Environmental Health Consultation Response

To	Hebe Smith
Date	01-11-2025
Planning Ref	AW/241/25/DOC
Site Description	36 Carlton Avenue Aldwick Bognor Regis West Sussex PO21 3LR
Date of Application	2025-10-20 00:00:00
Category	Discharge Of Condition
Recommendation	No Objection ~~No Objection — with conditions~~ ~~Objection~~ ~~Holding Objection~~

CLIENT	Counterpoint Properties Ltd	
SITE	Carlton Avenue, Rose Green, West Sussex	
PROJECT	Proposed Development Comprising 8 Dwellings	
DRAWING	003 Parking Plan	
DATE	29 07 21	
AUTHOR	AH	REVISION A - 13 08 21 Garages
STATUS	PL	
SCALE	1: 500 @ A3

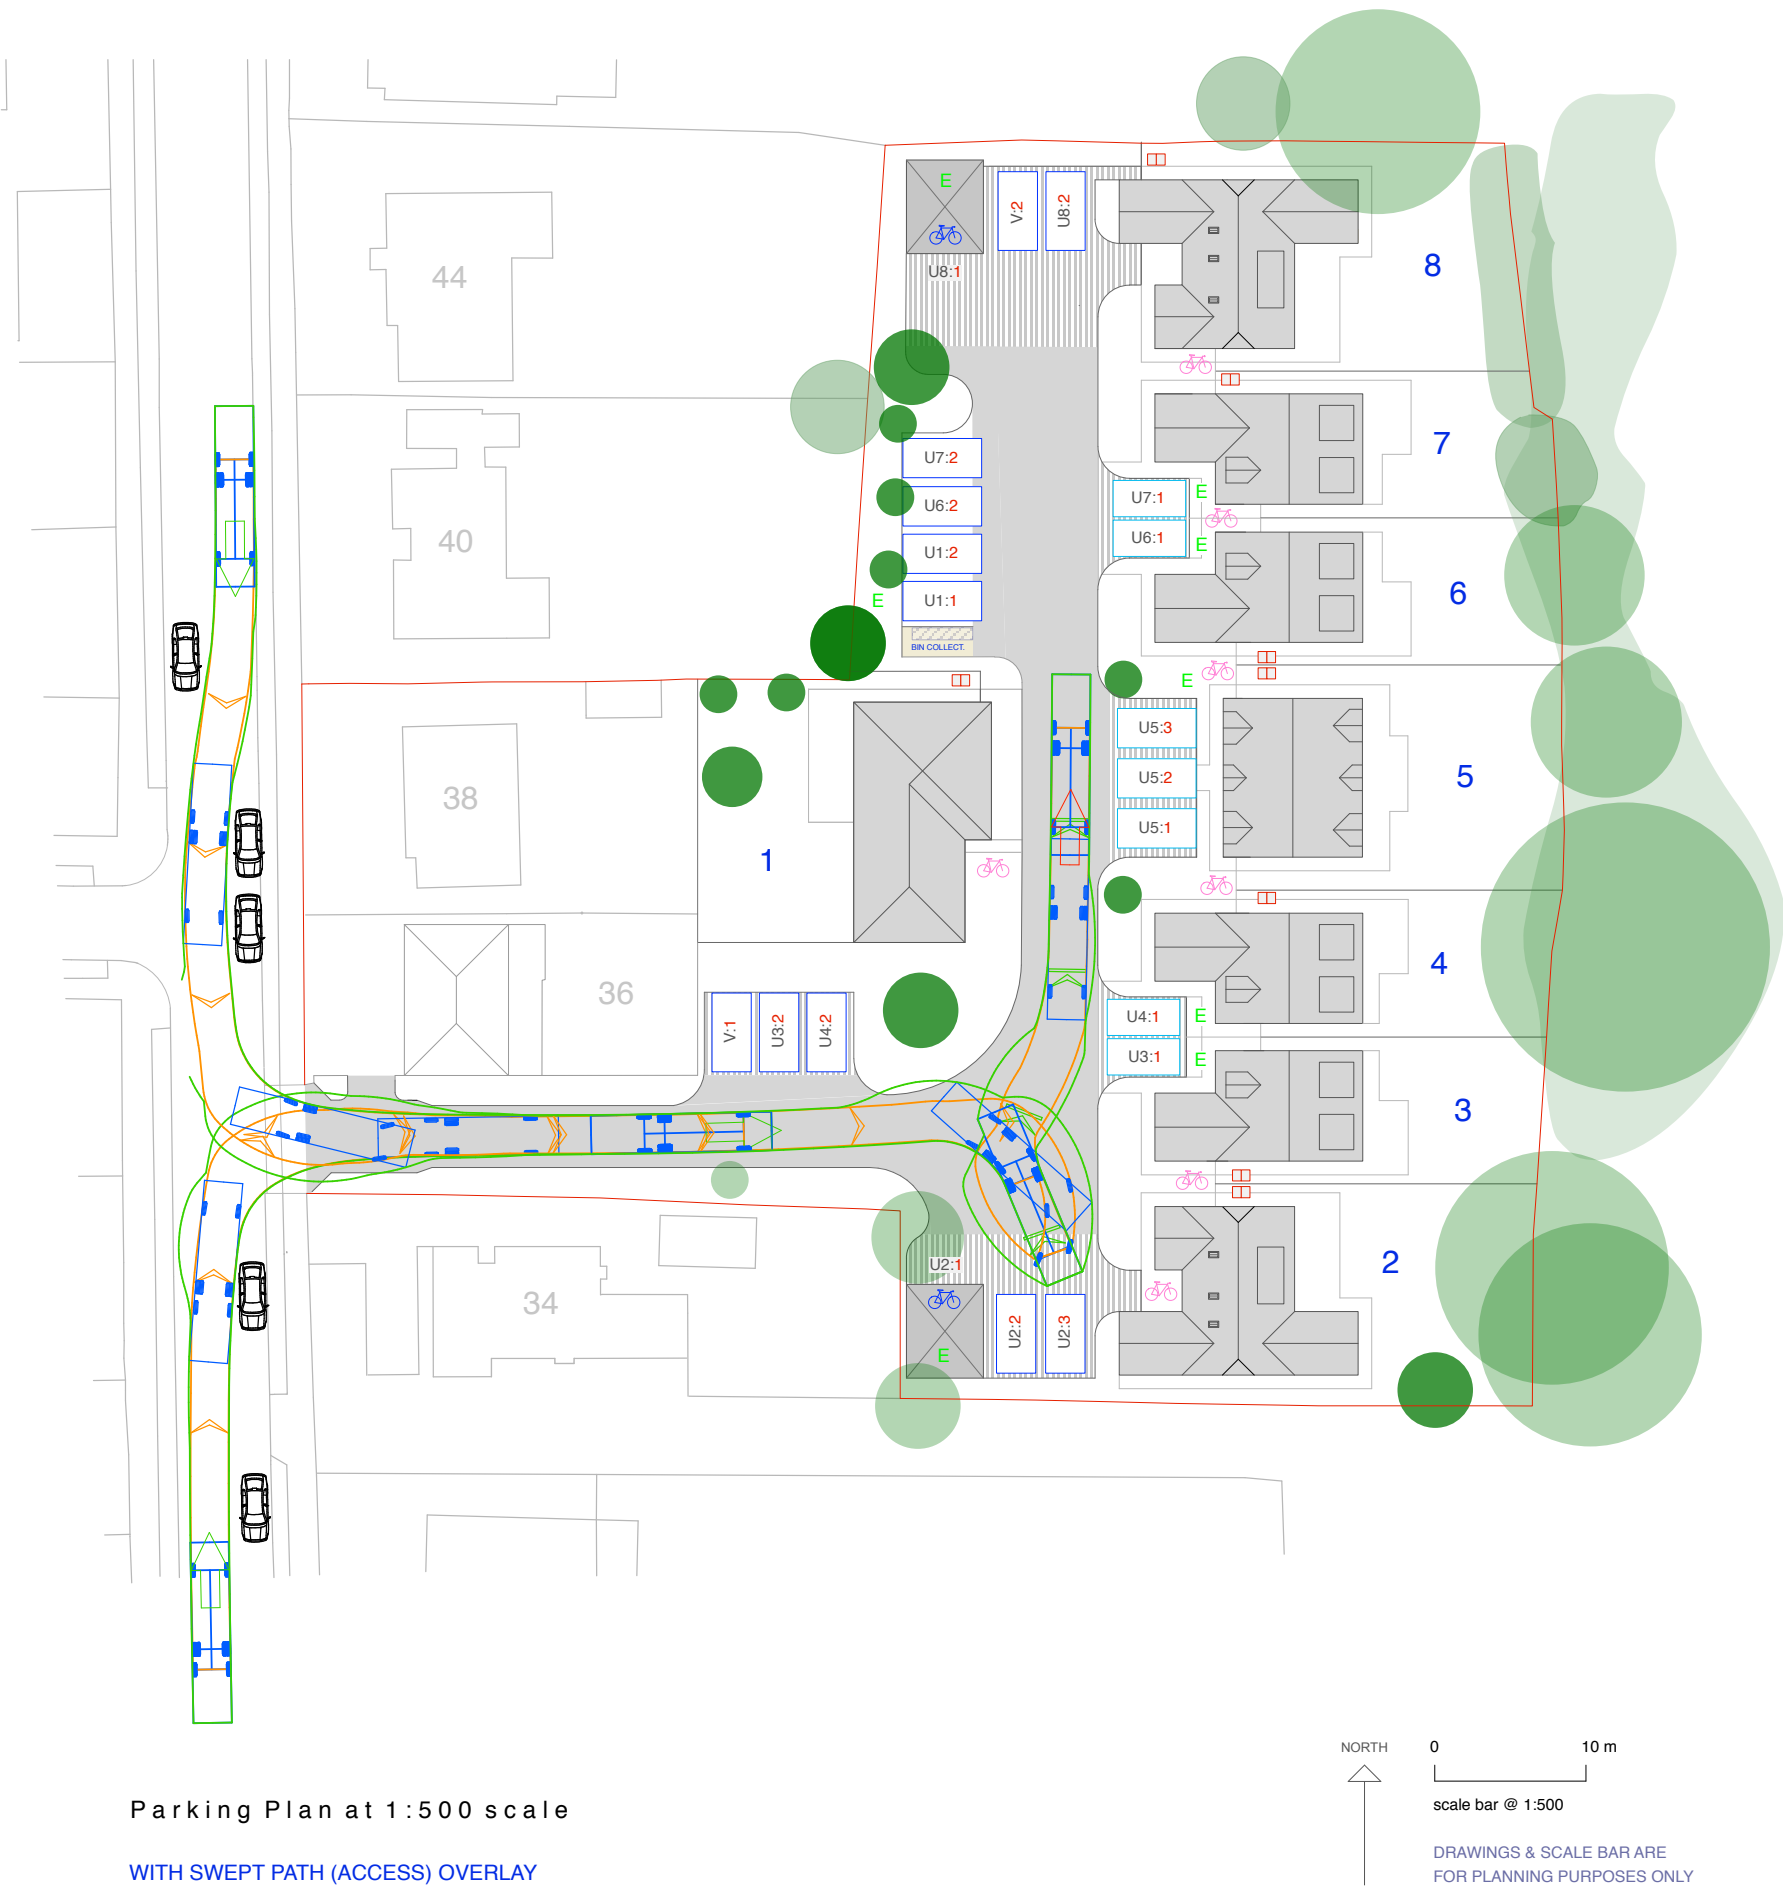
I have considered the above discharge of conditions and If 50% of parking places have EV changers I would have no objections to the discharge of 10.
